Little Elms,
46, Pigeonhouse Lane
Rustington.

Mr Cullinan,
Council Offices - re. 48, Pigeonhouse Lane
Lutchester.
Rustington
15.1.14

Dear Mr Cullinan,
re proposed alteration
at 48, Pigeonhouse Lane.
After careful considera-
-tion and conversation with
my neighbours at No. 48
I would be happier if this
new window could be
slightly less long, perhaps

Side Elevation (north)

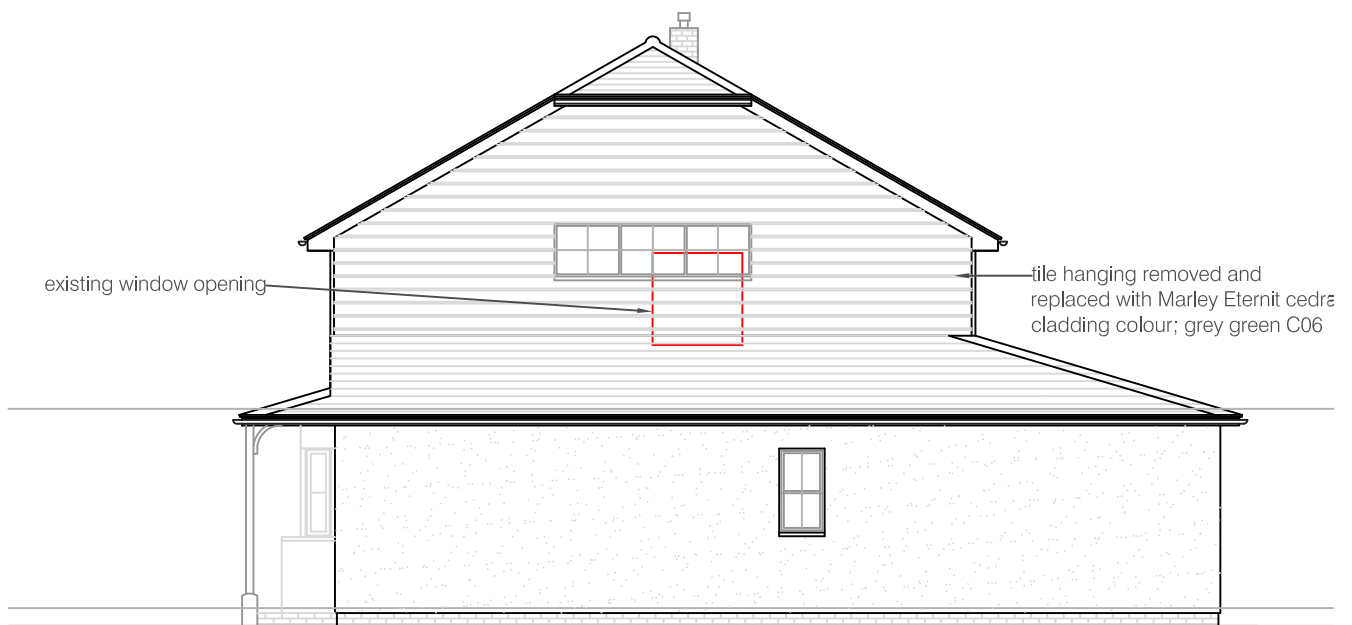
by one half of one section,
reducing the length by
one ⁶/₁₆ ~~section~~ and that the
glass should be mildly
obscured. I have spoken
to my neighbors who have
been extremely friendly
about this sensitive
problem but I do feel
my requests are
reasonable.
